COLORADO
Department of Transportation
Region 2

SH 83A
El Paso County

RE: Meadowlake Ranch Sketch Plan_EA17227_SKP184 - **REVISED addition of Hydraulics Review**

SKETCH PLAN

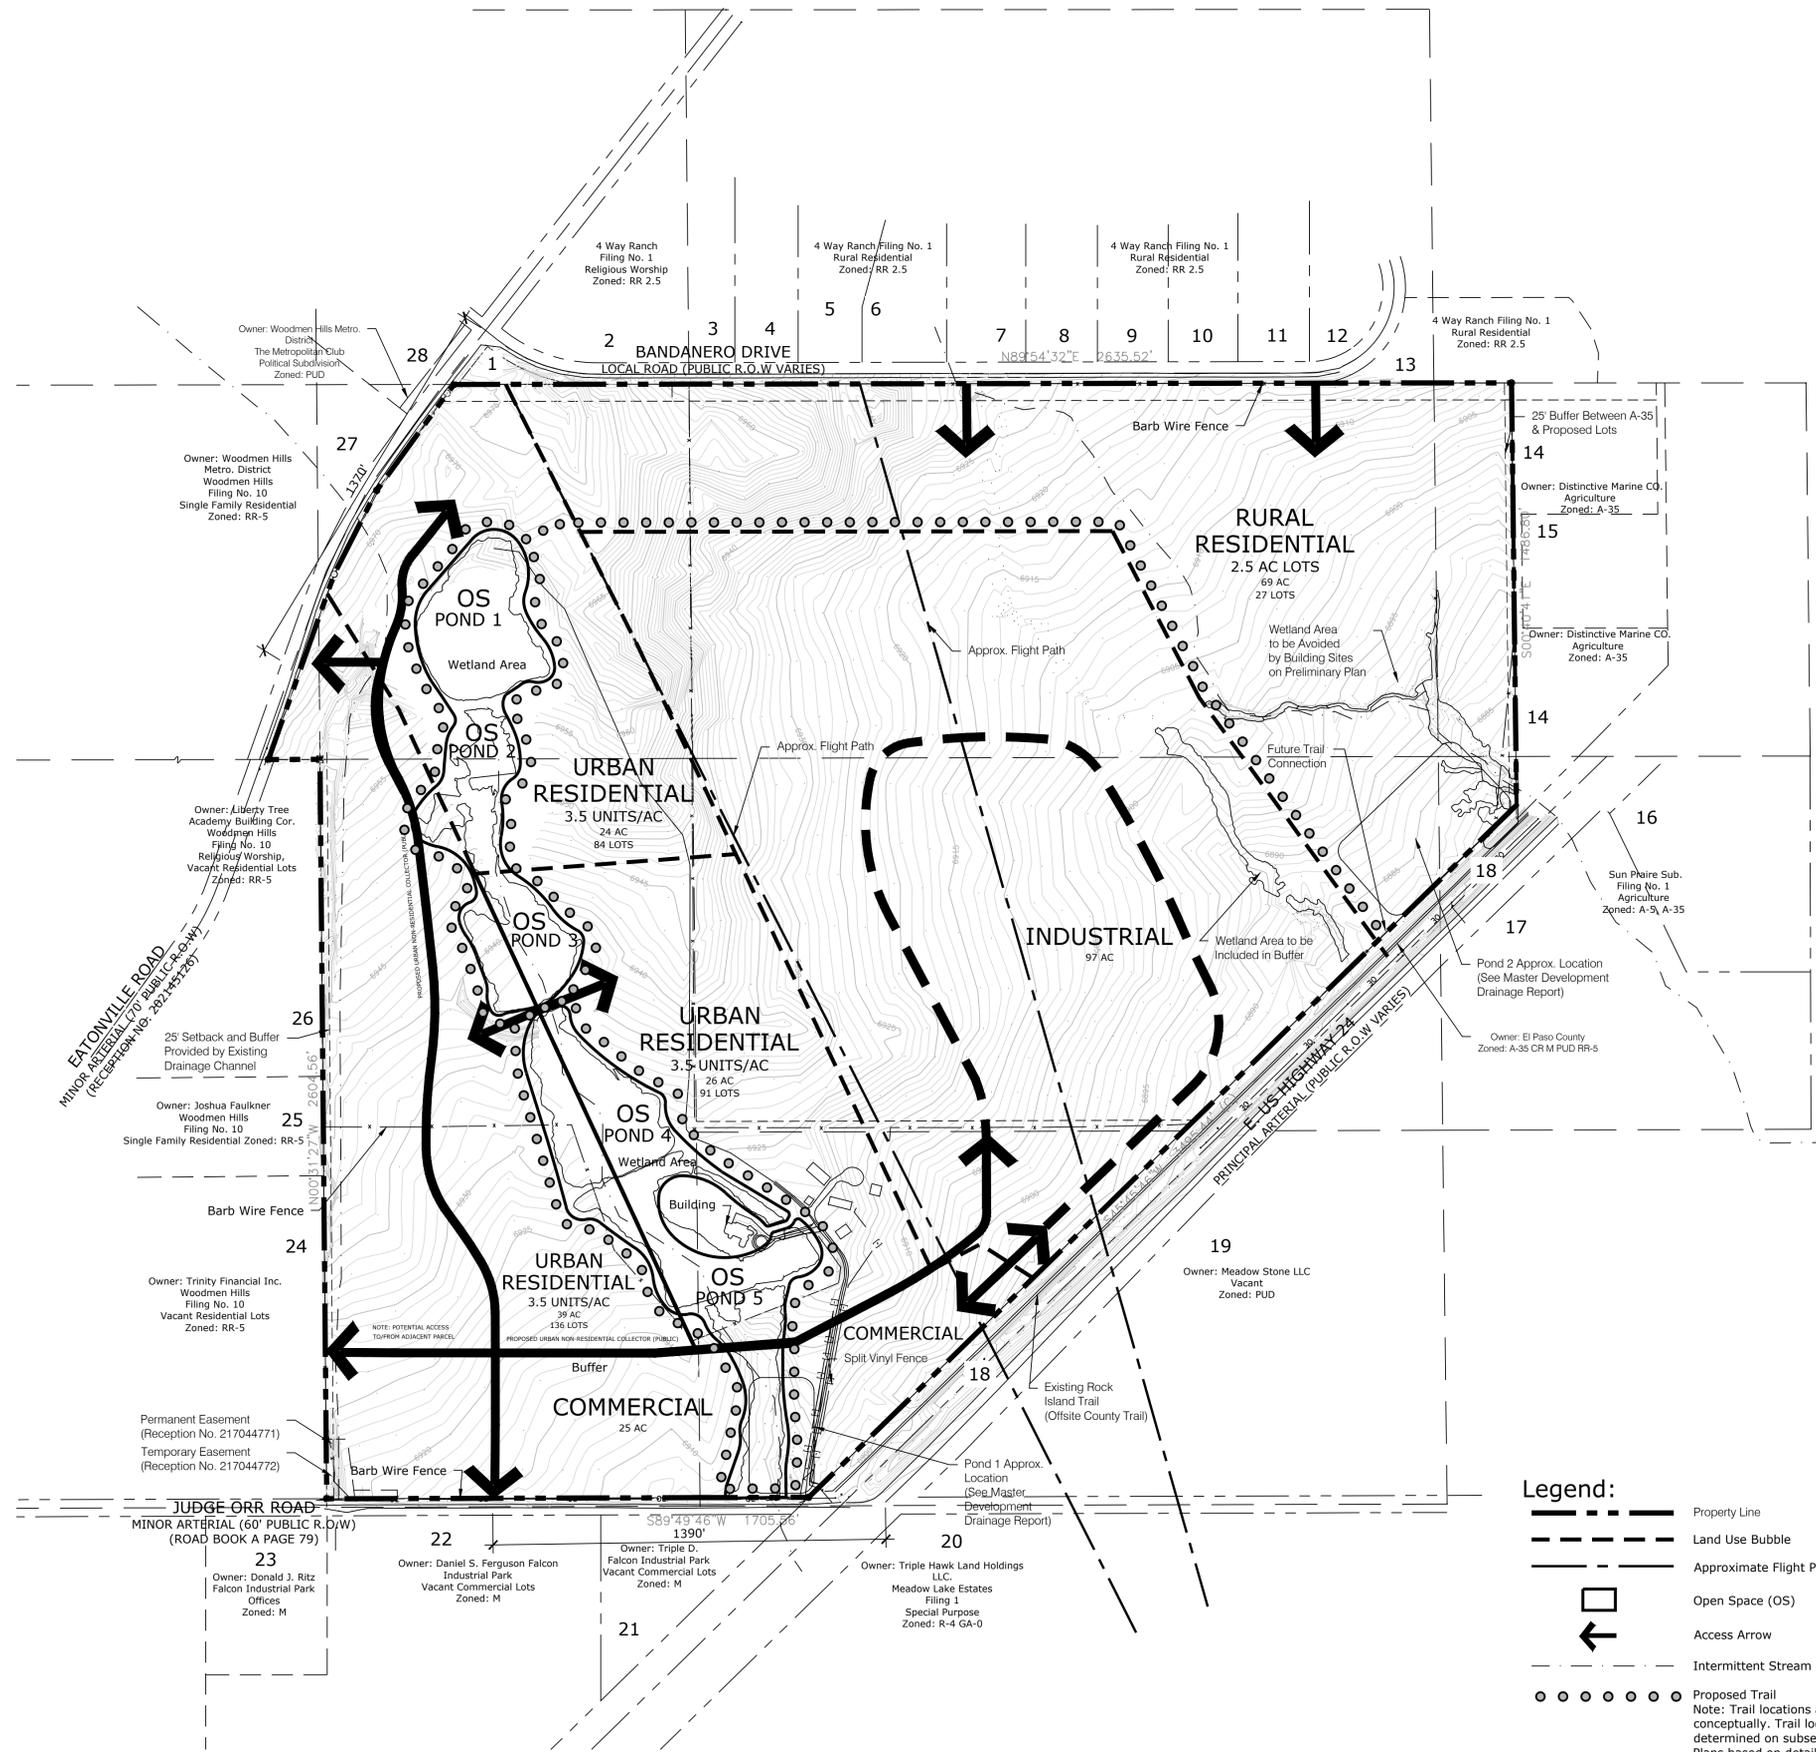
- b. Since US 24 is not being realigned, the developer will be required to construct the southwest-bound right turn deceleration lane along US 24 and Judge Orr Rd.

- c. Since US 24 is not being realigned, the developer will be required to construct the southwest-bound right turn acceleration lane along US 24 and Judge Orr Rd.

- d. The developer will be required to construct eastbound right turn deceleration lane on Judge Orr Road approaching US 24 to allow traffic to bypass thru/left traffic queue at the traffic signal.

- e. The southeast corner of the site should be preserved for the future re-alignment of Judge Orr Rd.
